PLANNING APPLICATION REPORT

REF NO: P/47/11/

LOCATION: 52 East Front Road
Pagham

PROPOSAL: Single storey extensions

ROOF PLAN

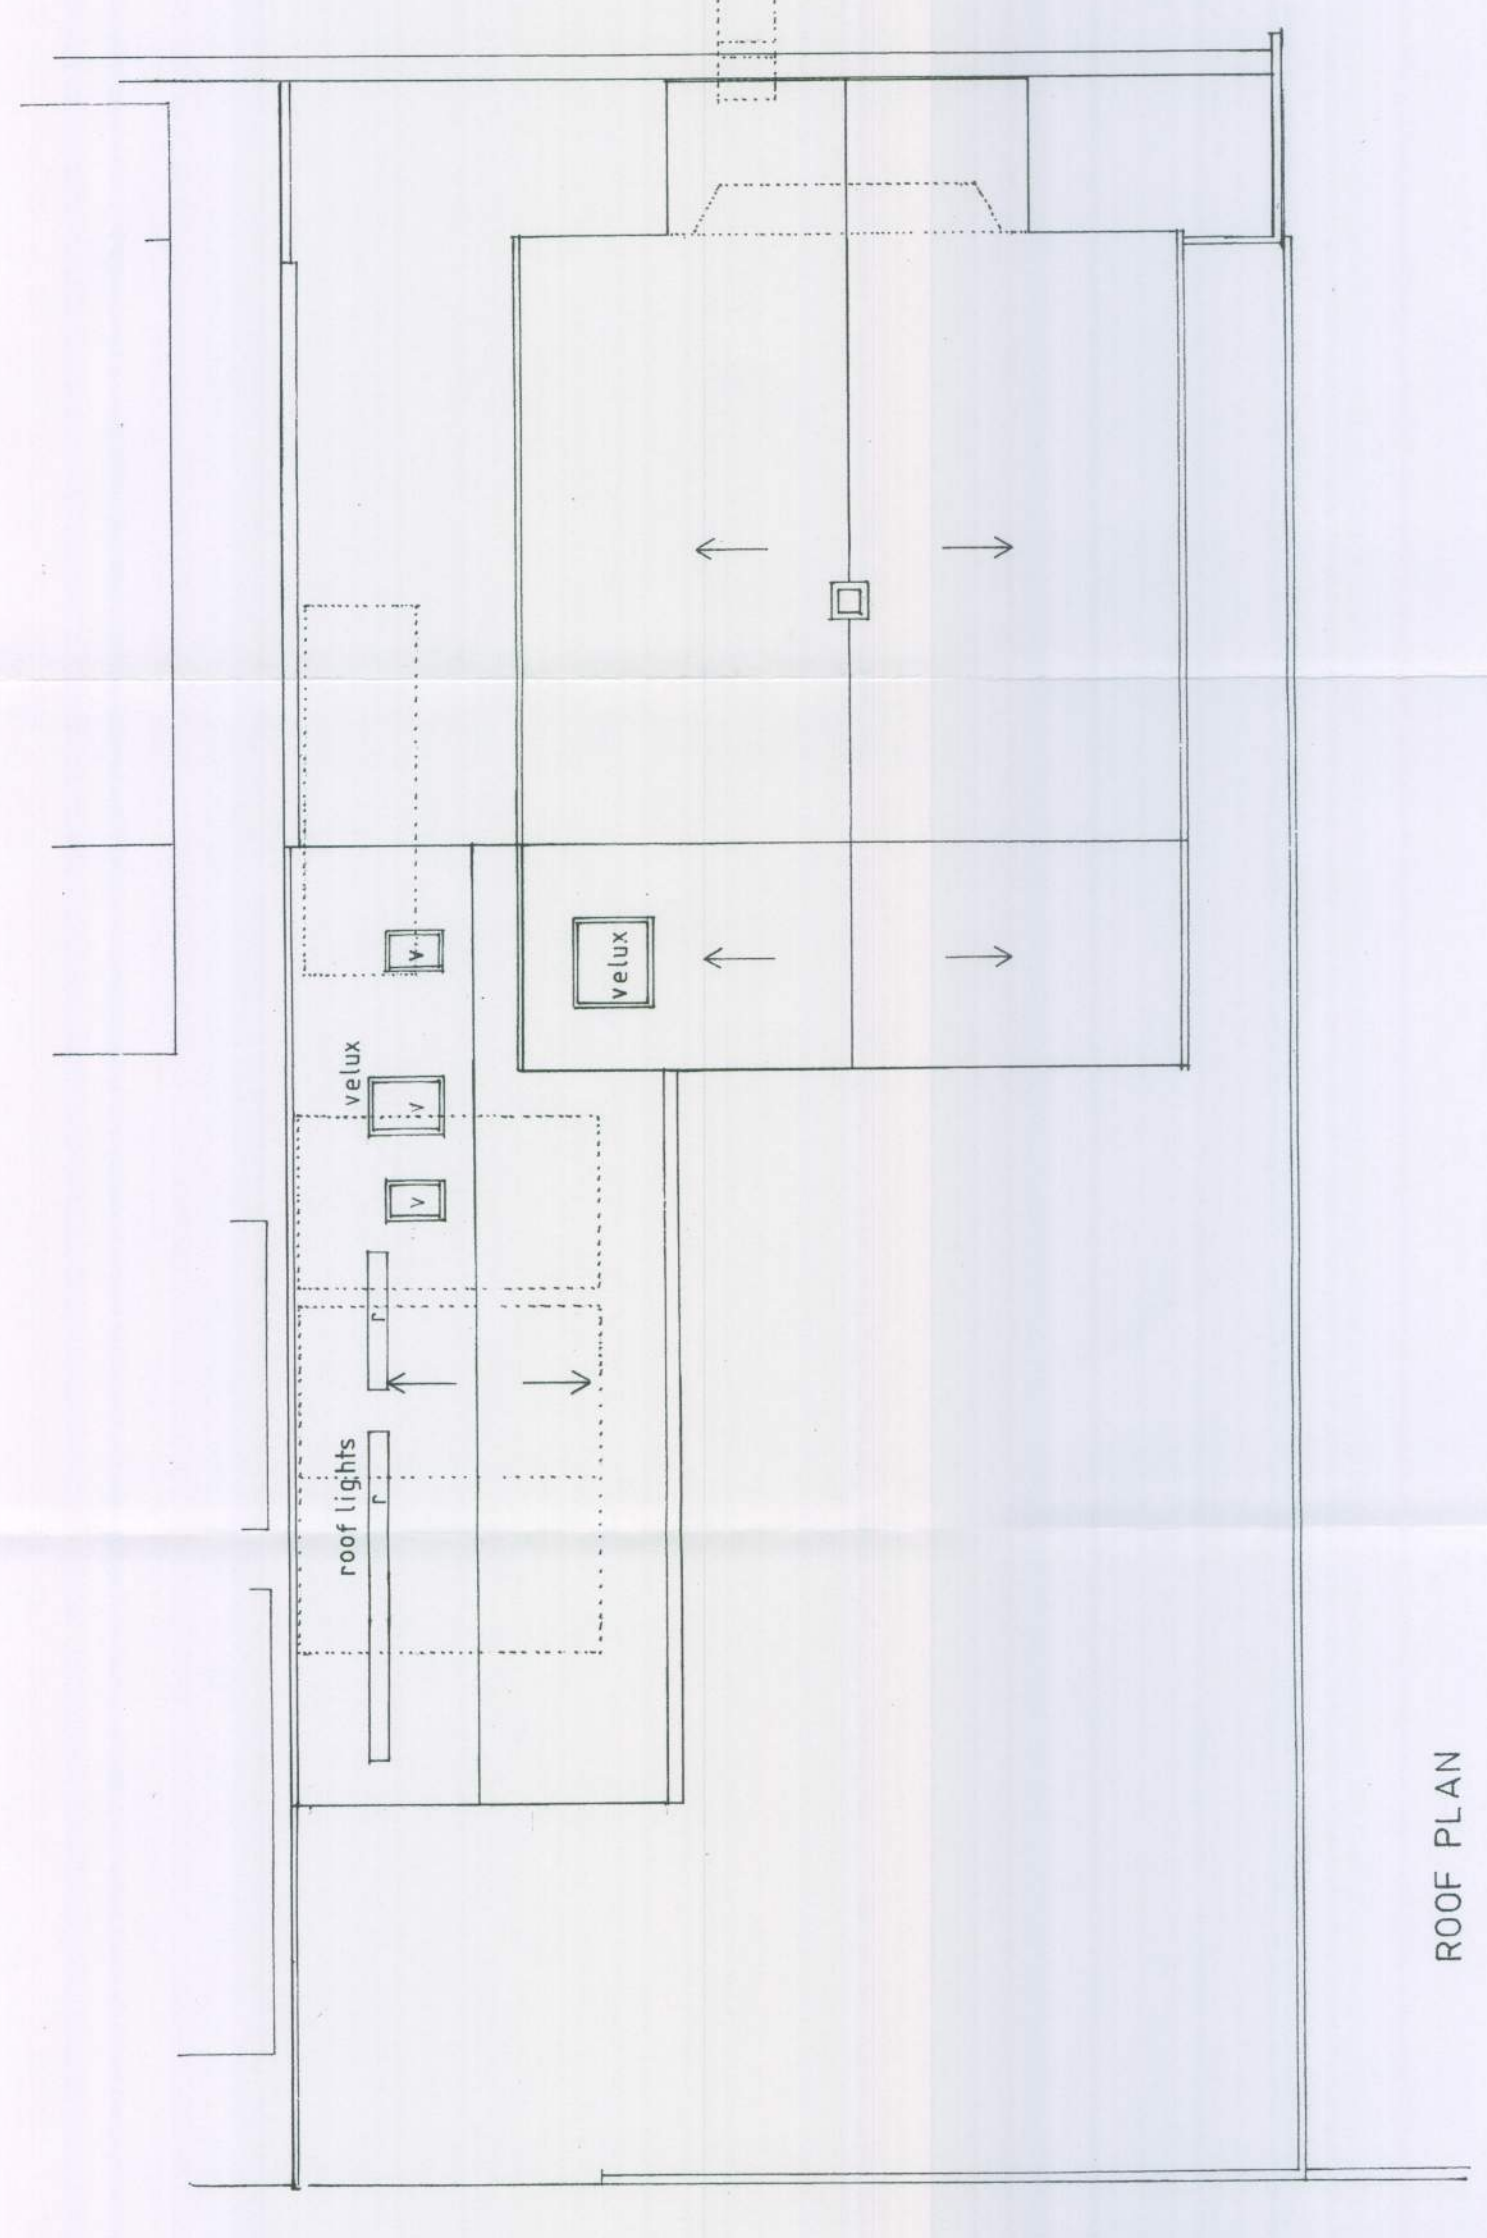
The application also proposes 6No. roof lights with the eastern roof slope of the extension. The site is located within the Pagham Area of Special Character in which development within roof slopes is not encouraged. The amount of roof lights proposed mean that they would appear as prominent feature when approaching the site from the east. These would appear out of character and in conflict with the objectives of the designated Area of Special Character. It is also considered that the introduction of roof lights across the width of the eastern roof slope would set an unwanted precedent for unsympathetic roof lights within the street scene and emphasise the unacceptable scale of the extension. Furthermore it is considered contrary to the character and development criteria set out in the Pagham Village Design Statement in relation to preserving the character of the area.
